# Hornsea Project 4 DCO Examination

Deadline & Submission

G7.13
Ver. A

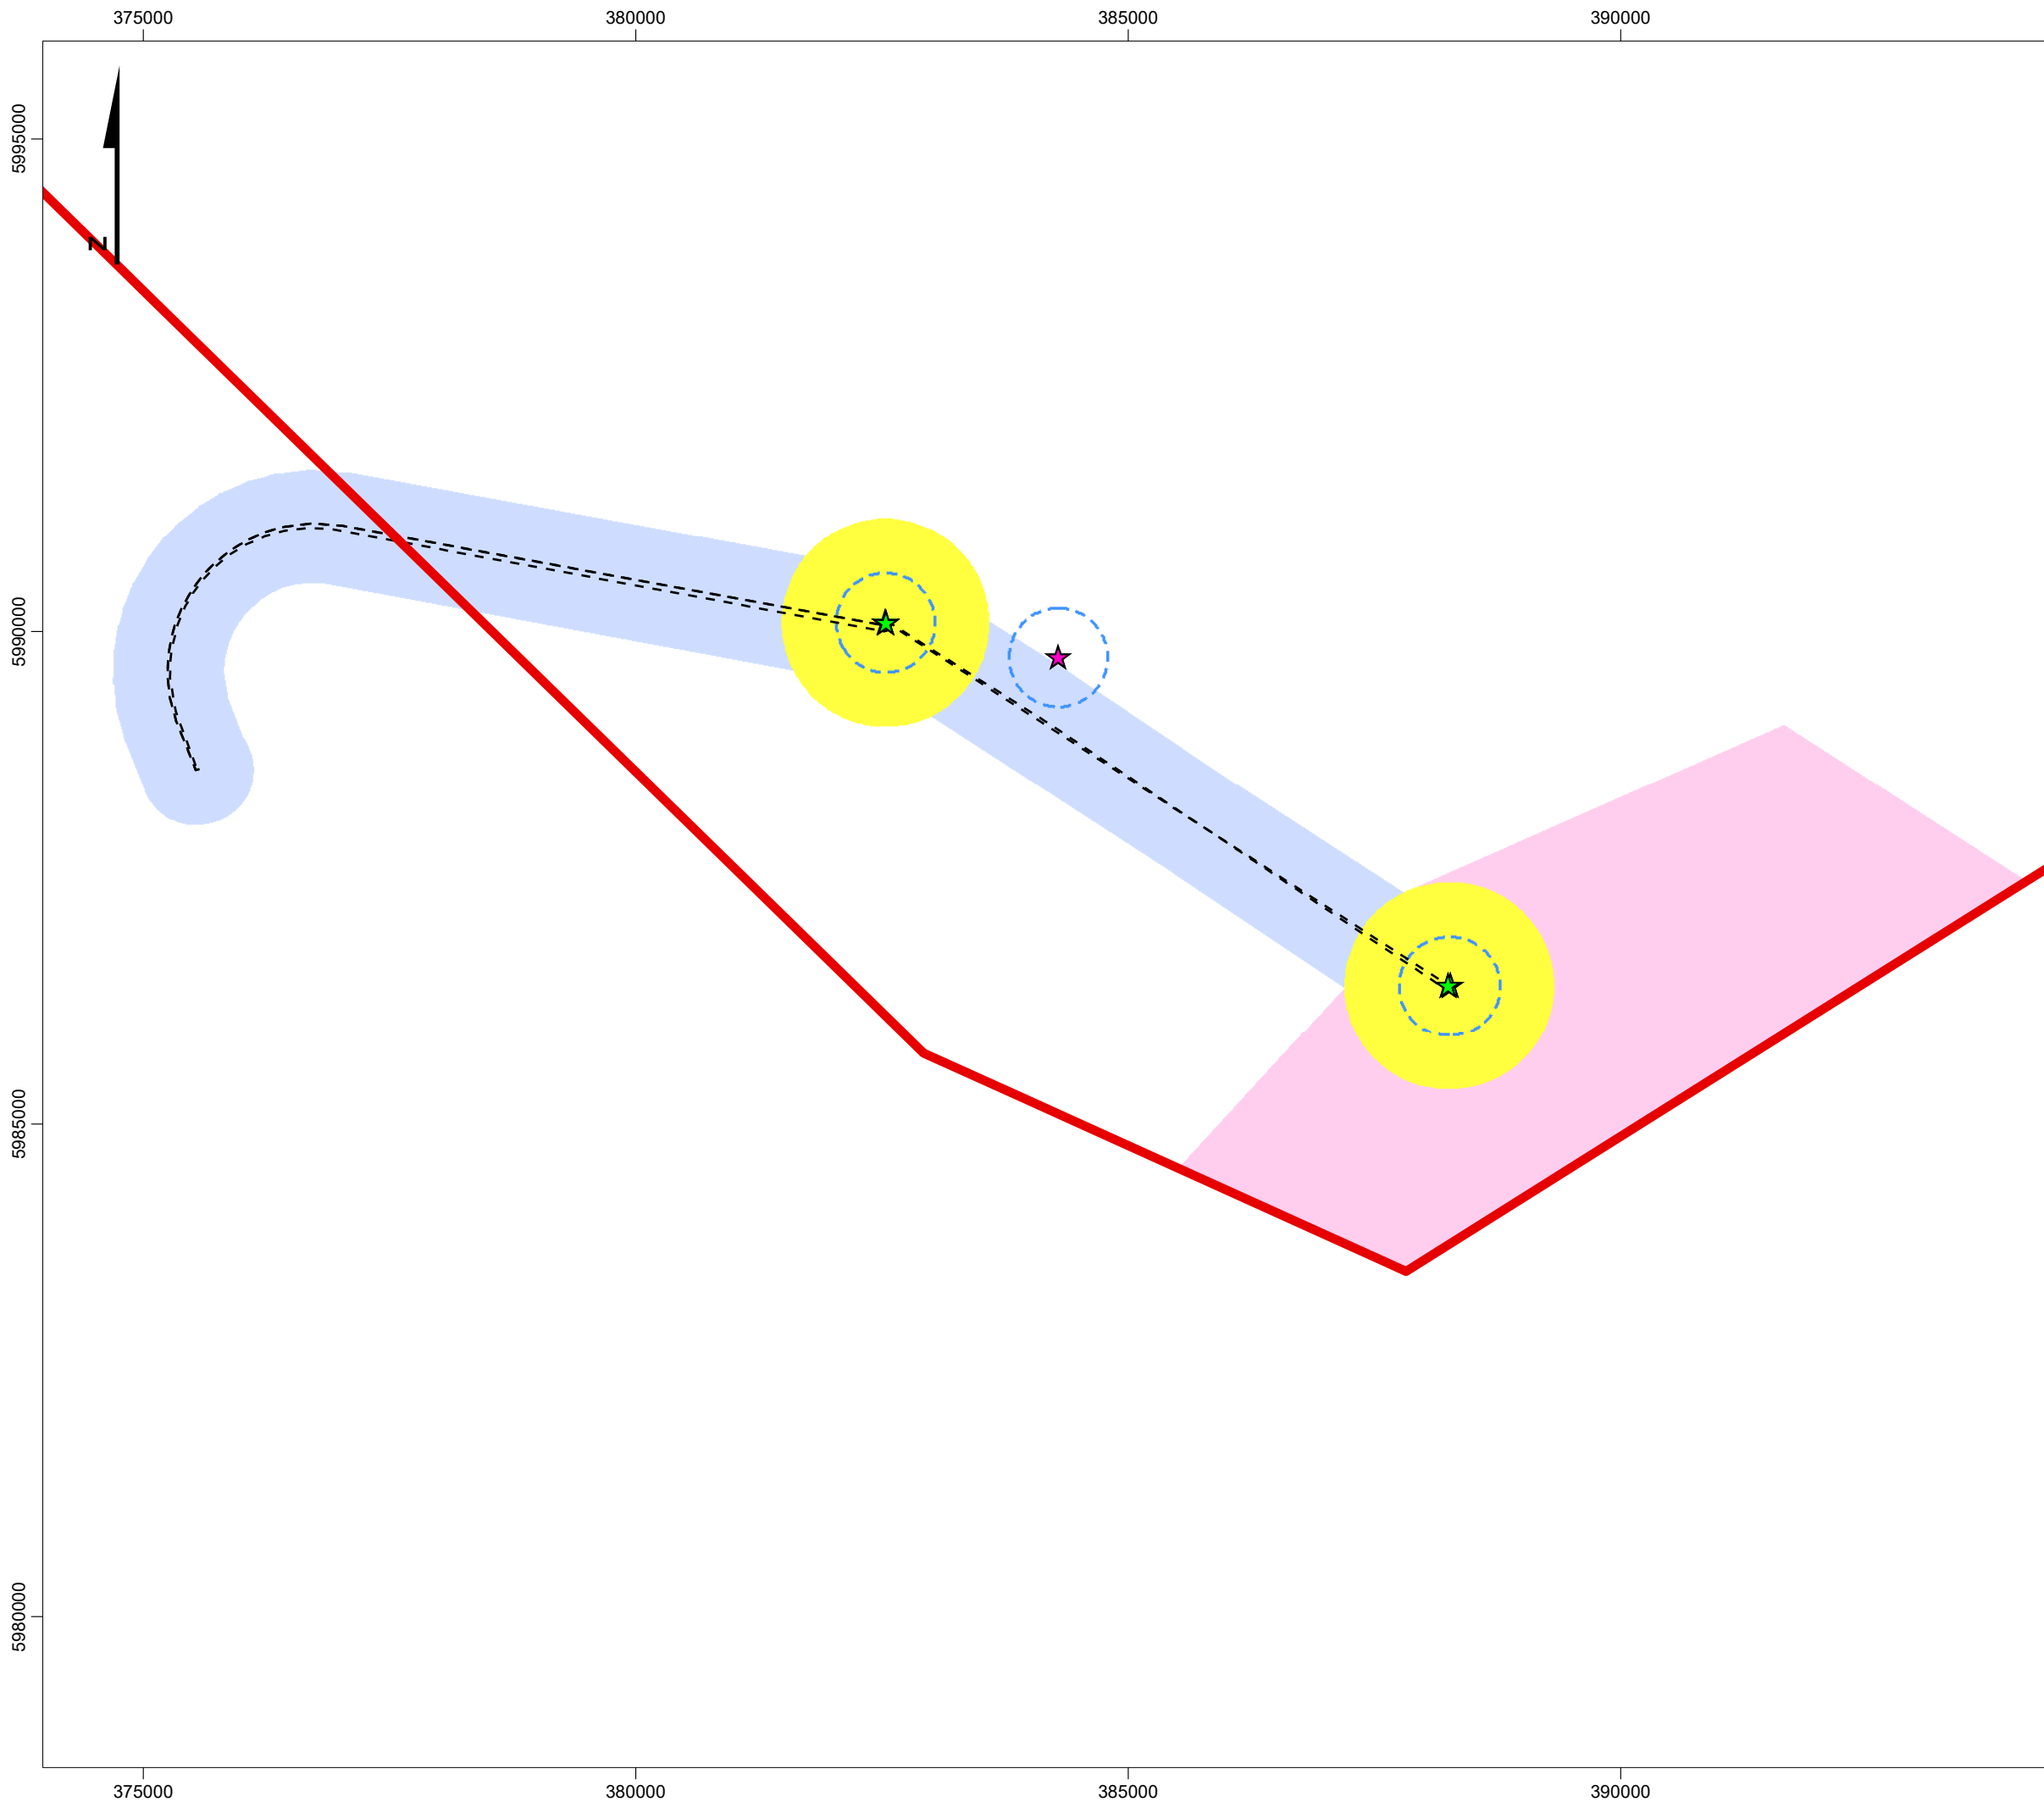
The Applicant presented Protective Provisions at Deadline 6 (REP6-040) which were revised at Deadline 7 (REP7-040 Schedule 1, Part 13). Even these revised proposed Protective Provisions would make it impossible for Johnstone Field operations to coexist with the proposed windfarm. This will be explained in greater depth in Section 2 of this document.

The Applicant maintains that its proposed Protective Provisions would allow sufficient space for helicopters to transit to, take-off from and land at the Johnston well locations compliant with CAA regulations. Both helicopter operators approached by Harbour Energy have advised that they would not be able to operate to the Johnston wellheads were the wind turbine generators placed as close as the Applicants Protective Provisions would permit. Their procedures (upon which they have each been granted their respective Air Operator Certificate) are based upon greater separation from obstructions and require a stabilised (i.e. straight line) final approach path to their landing. Whilst there are slight differences between the two operators, both could only operate if:

- any aviation corridor through the windfarm to the wellheads were at least 1.4km wide; and
- there were a radius, clear of obstructions (including rotor tips), of not less than 1.6km around each wellhead

In order to ensure security of supply for the UK and to transition to Net Zero, the UK needs the renewable industry and the oil and gas industry to coexist. The Applicant’s proposed Protective Provisions (REP7-040) would preclude at least two of the UK’s most widely used helicopter operators (both used by Harbour Energy)

from being able to fly to a rig at either of the Johnston wellheads and would thus not permit coexistence and would furthermore prevent the Johnston Field owners from fulfilling their legal obligation to maximise economic recovery from the field.

Harbour Energy re-iterates that its existing proposed Protective Provisions (a 3nm radius around each wellhead in addition to the marine corridor). Were the Protective Provisions amended to permit sufficient space (1.6km obstacle free radius around each wellhead and 1.4km wide aviation corridors to and from each wellhead, then, subject to the Applicant compensating Harbour Energy for delays to its rig programmes arising from flight restrictions resulting from the presence of the windfarm, such amended Protective Provisions could be acceptable to Harbour Energy.
